CITY OF ALBUQUERQUE

April 8, 2008

**Re: Yearout Mechanical Warehouse, 8501 Washington St. NE,
Approval of Permanent Certificate of Occupancy (C.O.),
Engineer's Stamp dated 09/19/07 (C-17/D001U10)
Certification dated 4/07/08**

DRAWN BY: [Name]
REVIEWED BY: [Name]
DATE: 10/1/07
PROJECT NO.: [Number]
DRAWING NAME: TRAFFIC CIRCULATION LAYOUT

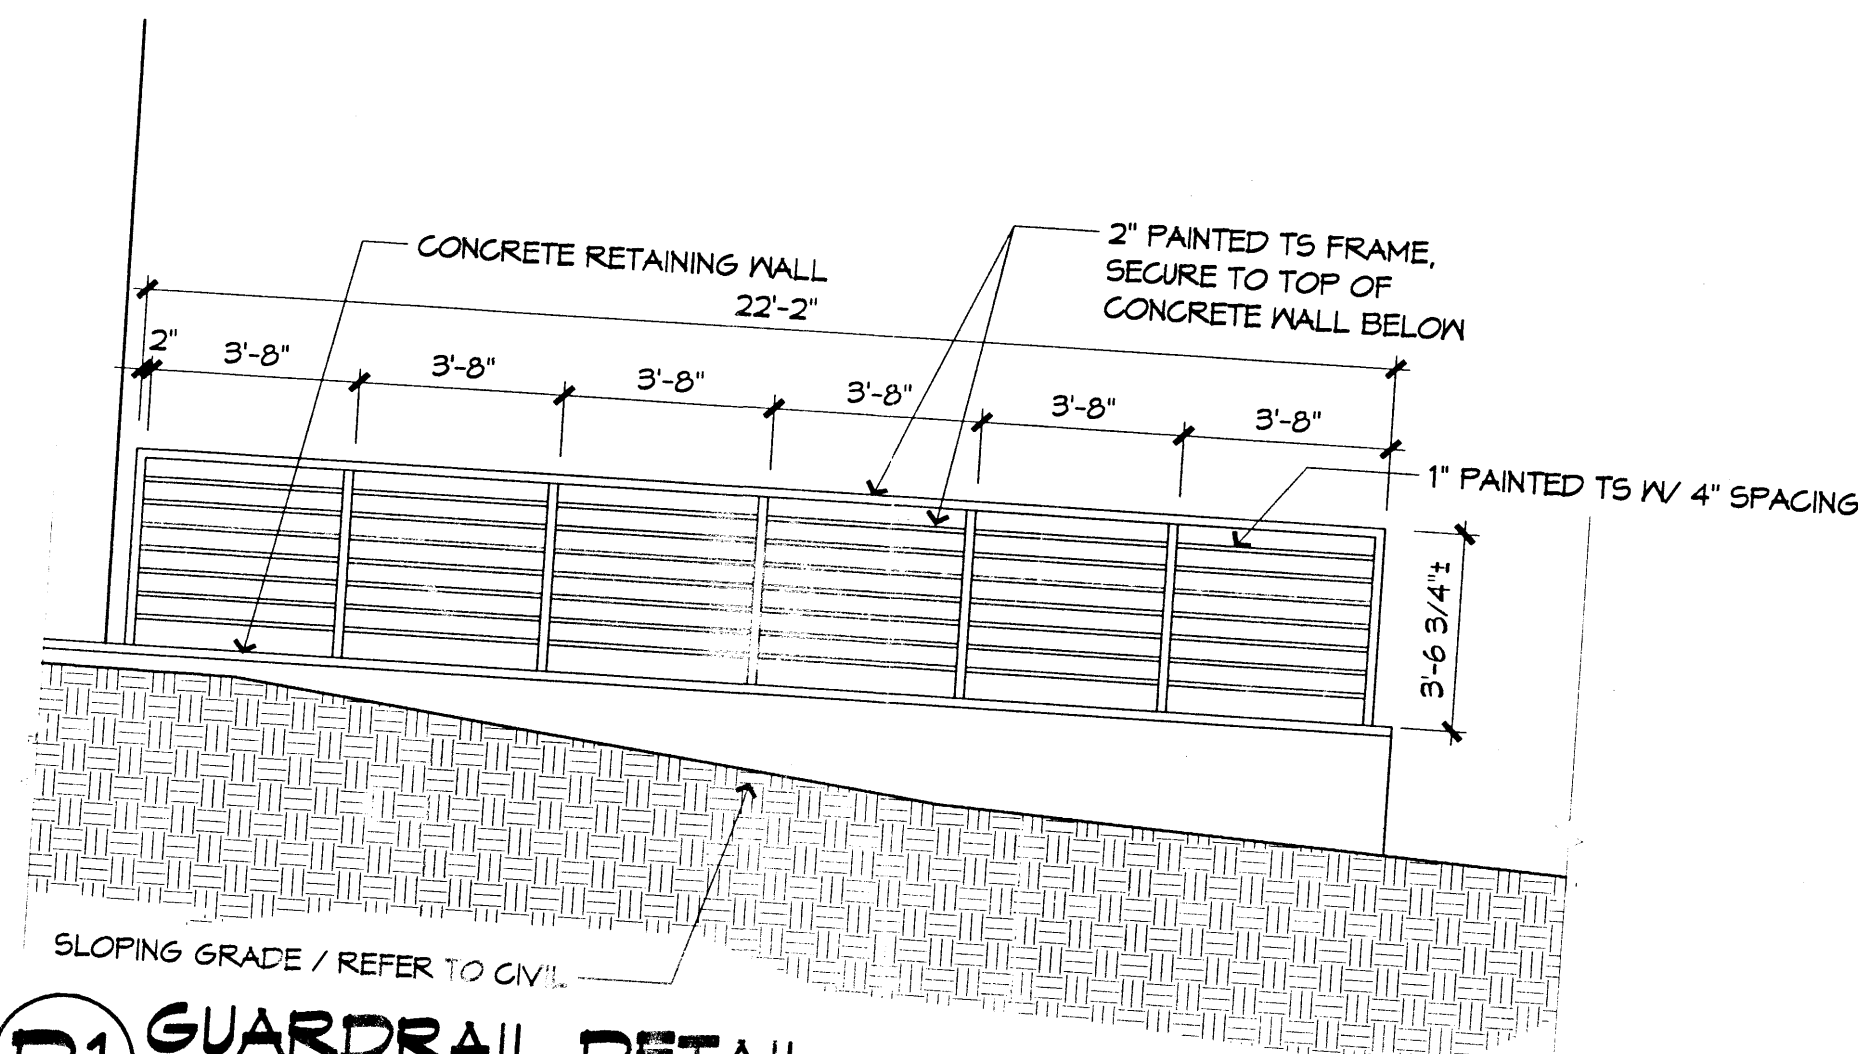
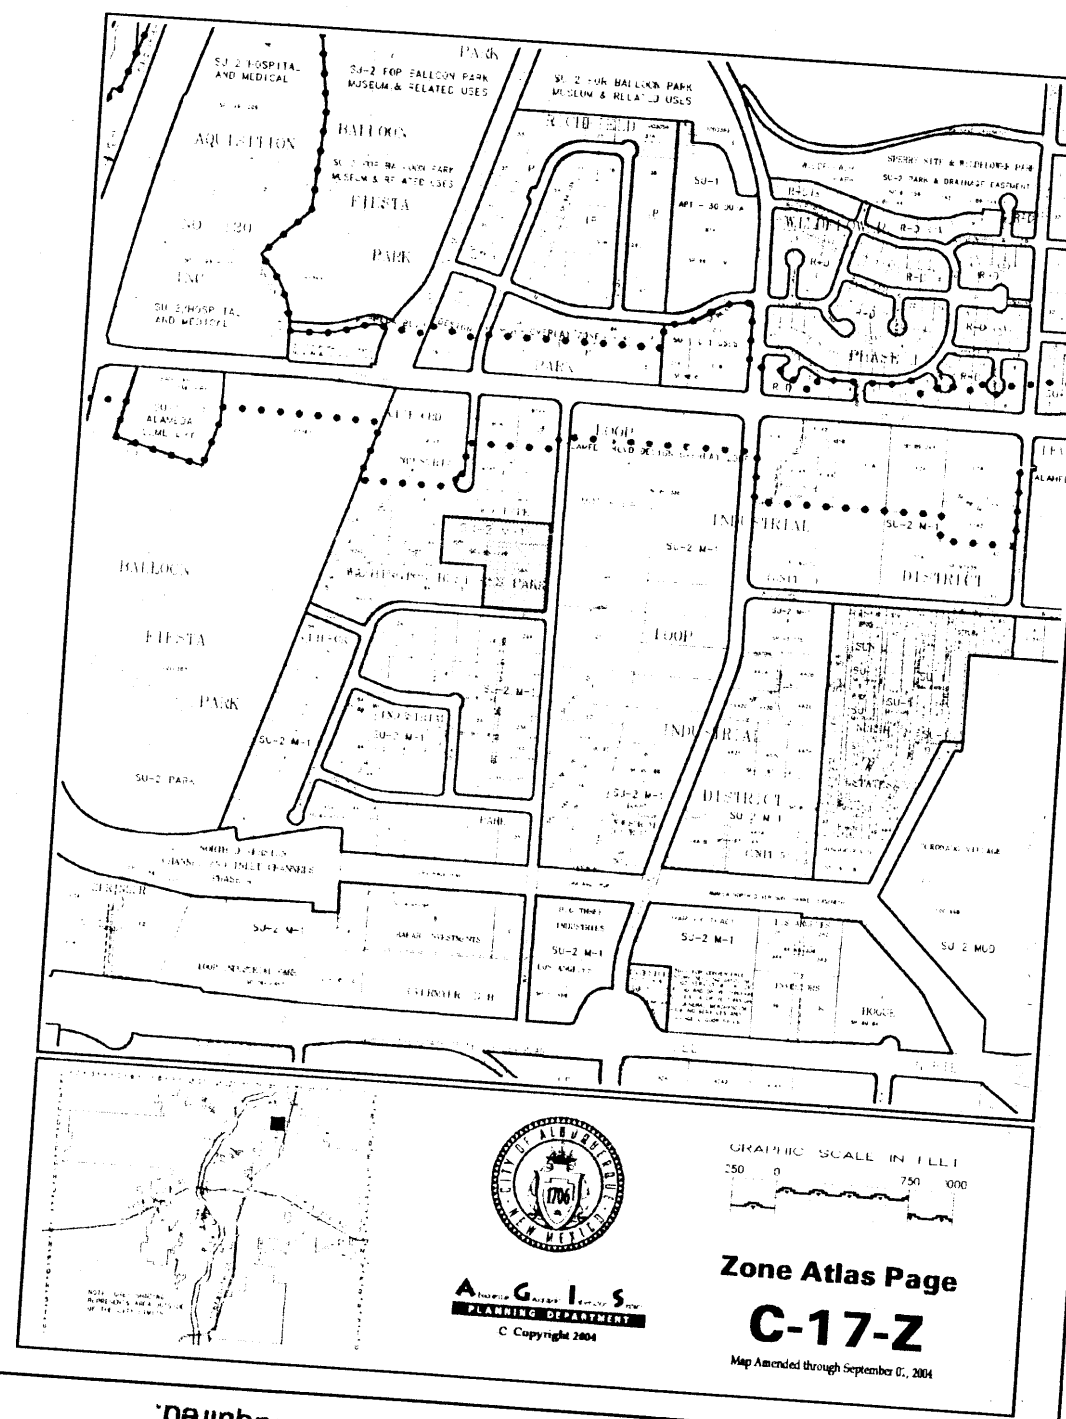
1. For passenger vehicles, the minimum end island radius is 15 feet. This radius is needed at the one-way entrance and the entrance off of Washington Place and at the one-way on Washington Street.
2. Please ensure all ramps are ADA compliant.
3. One-way signage and striping will be required at the one-way entrances and exits.
4. It appears the sidewalk overlaps the property line; therefore, a sidewalk easement is needed for the sidewalk along Washington Street.
5. Remove "some" from note #24. All wheelchair ramps within the City Right-of-Way require truncated domes; also amend the northern most drive-way note to truncated dome in lieu of "half dome."
6. Detail the operation of the gate. Will the gate only be open during business hours or will the gate stay closed?

1. List radii for all curves shown.
2. For passenger vehicles, the minimum end island radius is 15 feet.
3. List the width and length for all proposed parking spaces.

5. Please show the location of the nearest driveways on the adjacent lots.
6. Define the distance between the drives on Washington Street.
7. Show a vicinity map on the plan.

- 1" = 50'
 - 1" = 40'
 - 1" = 20'
 - 1" = 10'
 - 1" = 100' (for overall layouts only)
10. The southernmost entrance on Washington Street does not appear to meet City Standards. Please provide additional geometric information for this drive. How will a ramp be fitted into this drive?

11. Show all sidewalk, both existing and proposed, on the plan. Please note that all proposed sidewalk should be placed at the property line, not the back of curb. Call out the width of all sidewalk.

- 13. Please include two copies of the traffic circulation layout at the next submittal.
- 14. List the width of all driveways. To accommodate ADA standards, all driveways must have a 3-foot wide pedestrian access path. This path must have a cross slope of no greater than 2%.
- 15. Please ensure all ramps are ADA compliant.
- 16. Clarify the extents of the current phase.
- 17. Will this building require a pedestrian path? Please check with the zoning department regarding this.
- 18. I understand that a re-plat of this site is currently in process with the Development Review Board. Therefore, any comments regarding required easements will be postponed until the proposed plat has been approved. Include a copy of the recorded re-plat with the next submittal.

I believe that I have answered all your concerns in regards to the TCL for Yearout Mechanical Warehouse. I do however; have questions in regards to your comments #11 and #18.

Comment #11 asks for our side walk to start at the property line and not at the back of curb. There is an existing 10'-0" utility easement that starts along the property line. There are full mature trees planted on a slope up to the street (at the far south end there is 4'-0" retaining wall in place). There is also a precedent in that, all other sidewalks in this industrial park are all pushed out to the curb. I am showing a new 6'-0" side walk next to the curb to keep with other surrounding properties, easy of construction on the slope and to save the existing trees. (Please see attached labeled photos).

I believe that I have answered all your concerns in regards to the TCL for Yearout Mechanical Warehouse. I do have written responses for you comments #4 and # 6

Comment #4 asks for a side walk easement to be shown. This will be shown on our updated re-plat for approval. - *Not on plat - will need paper easement*

Comment #6 asks for the operation of the gate. I was informed that the gate is always left closed. However, during business hours the gate is operated by a sensor for opening and exiting the site as needed. After business hours the gate is operated by a key card for opening and sensor for existing.

Yearout Mechanical, Inc.
Warehouse Addition
8501 Washington Street NE
Albuquerque, NM 87113

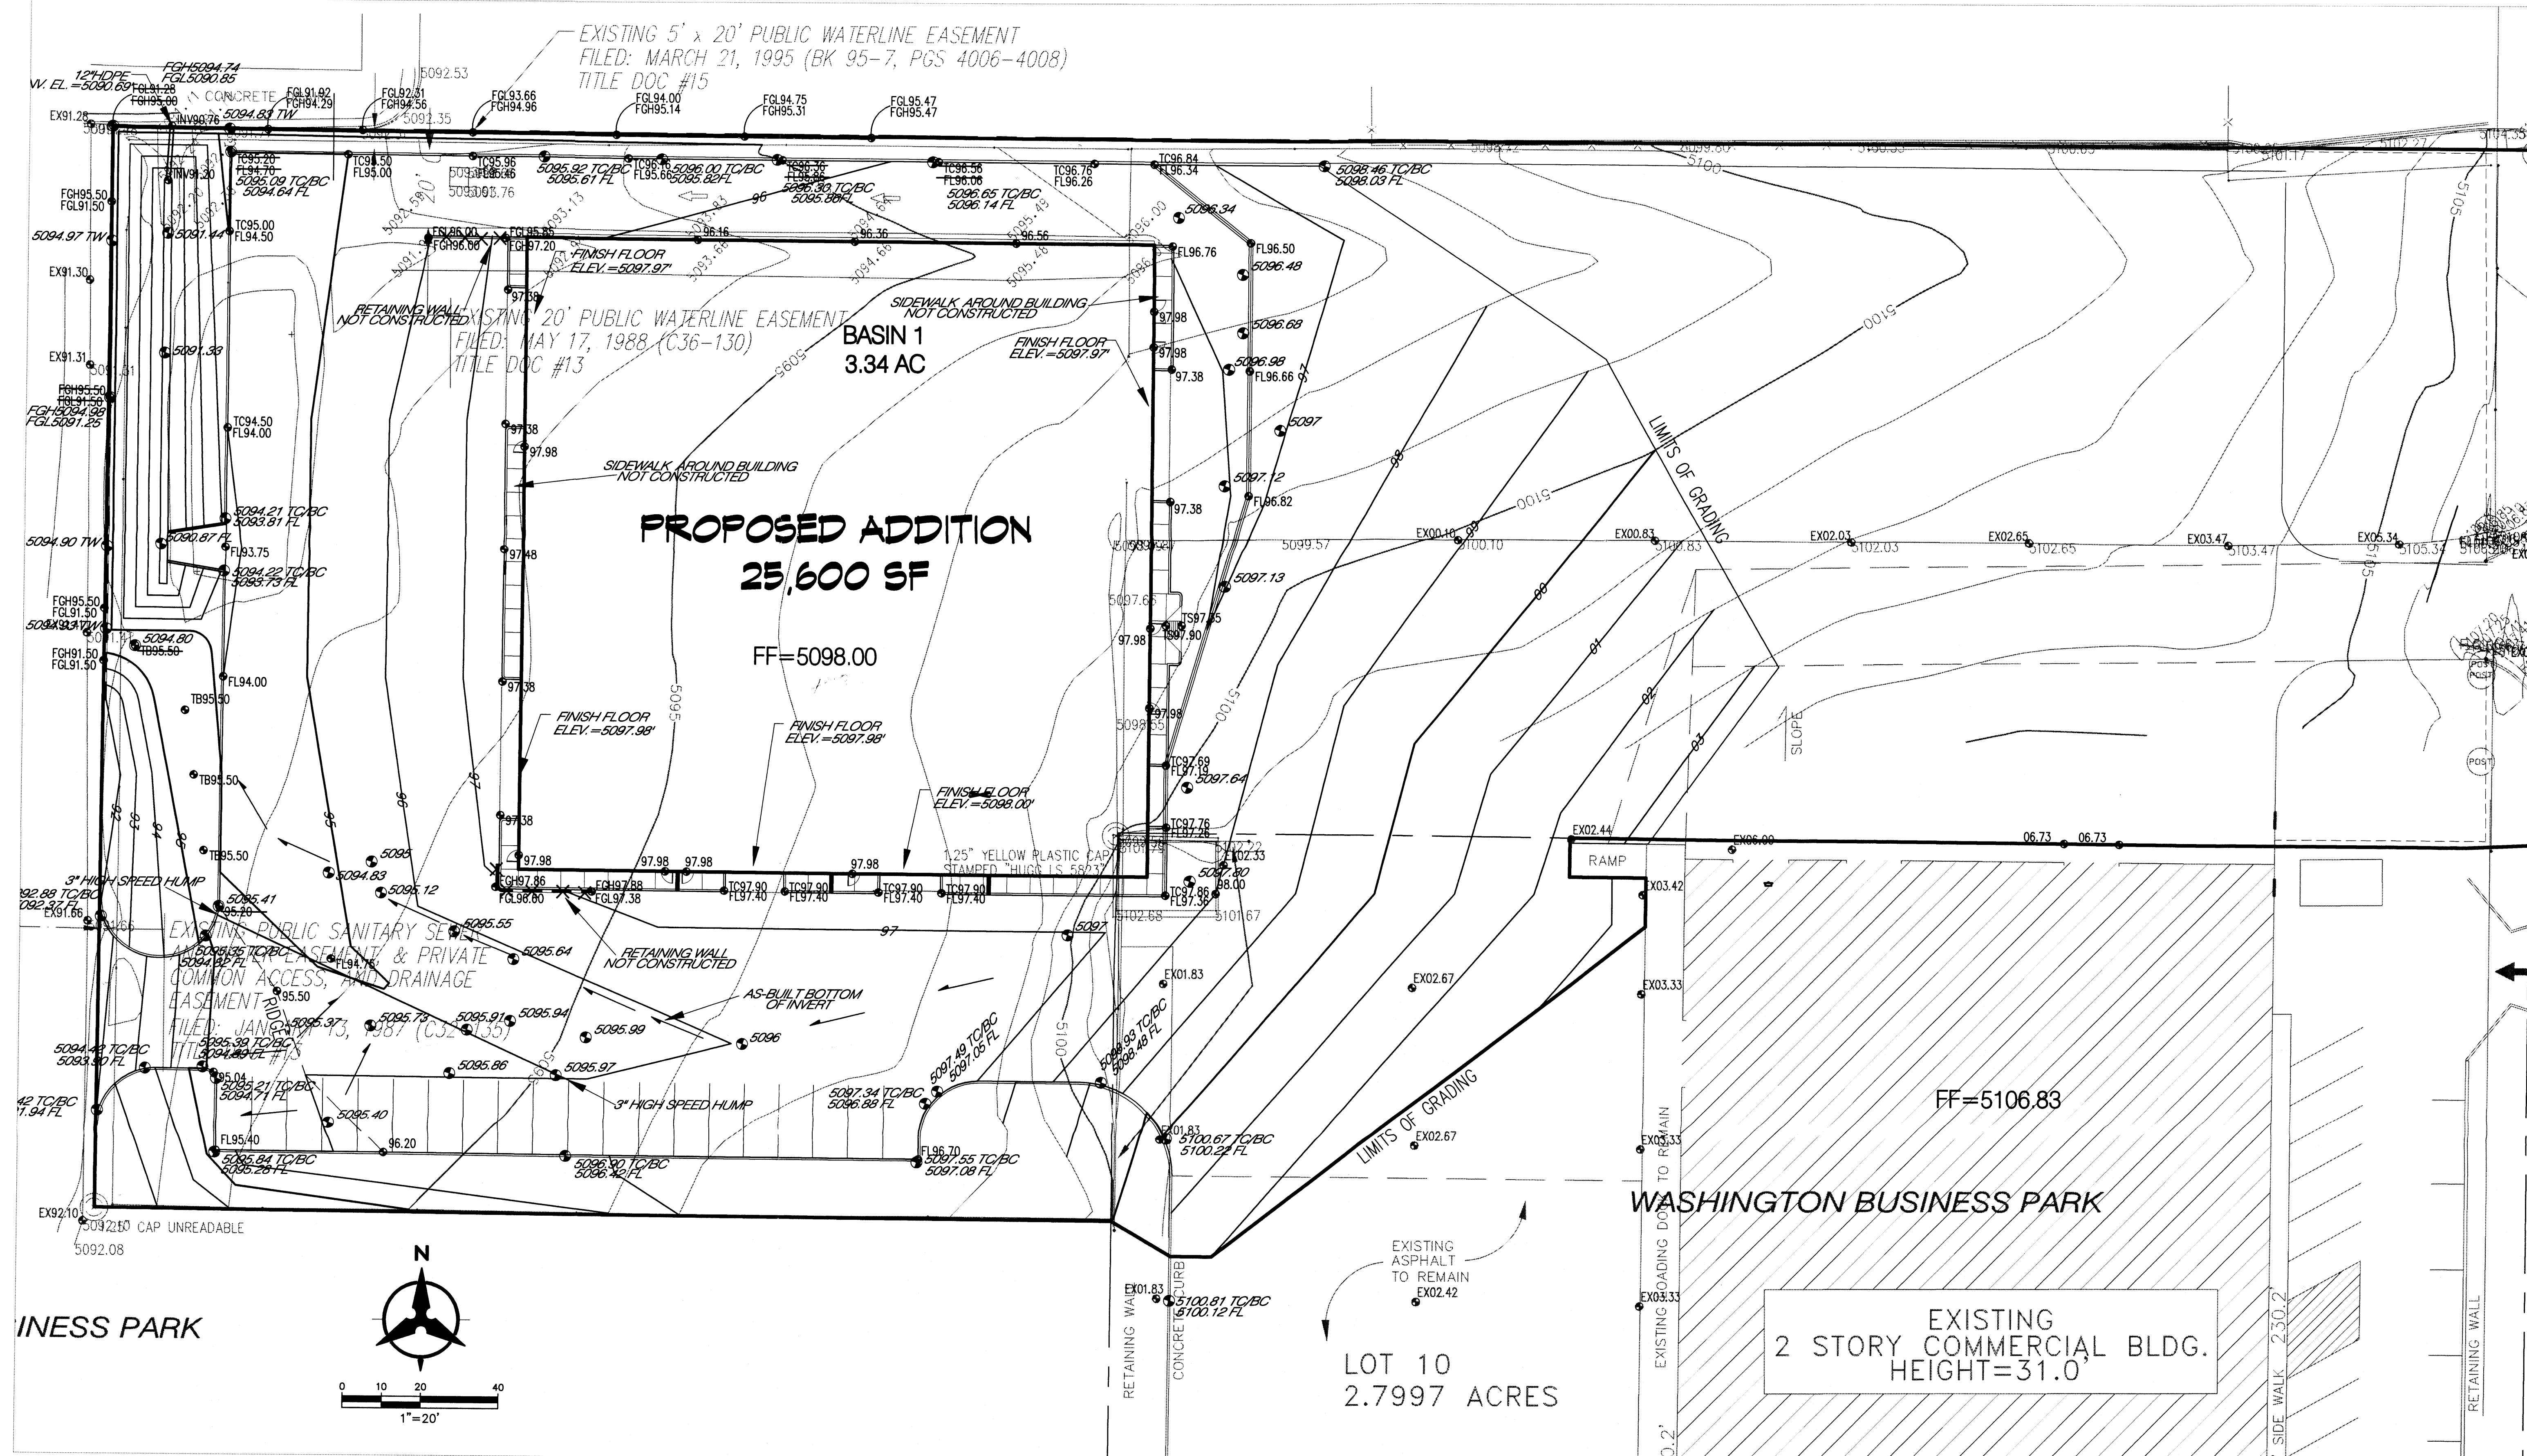
The pond volume will need to be certified, as well as, the additional survey information.

1. Per the *Development Process Manual*, Chapter 27, Section 1, "Standard sheets must be 24" by 36" having a margin of 2" along the left and 1" on the top and bottom."
2. The approved plan defines the allowable discharge as 2.3 cfs / acre. However, your updated plan changes the project area. Based upon your defined project area (2.97 acres), the allowable flow is 6.8 cfs.

1. According to your conversation with Bruce Stidworthy on September 19, 2007, the sheet size of 30"x42" is acceptable for consistency throughout the building permit set.
2. Our previous submittal did not take into account the entire site and therefore we have updated the calculations. The area that is disturbed by this project is 3.34 acres. According to the approved drainage plan the allowable discharge is 7.68 cfs (2.3cfs/acre). The pond and outlet are sized to safely pass this runoff.
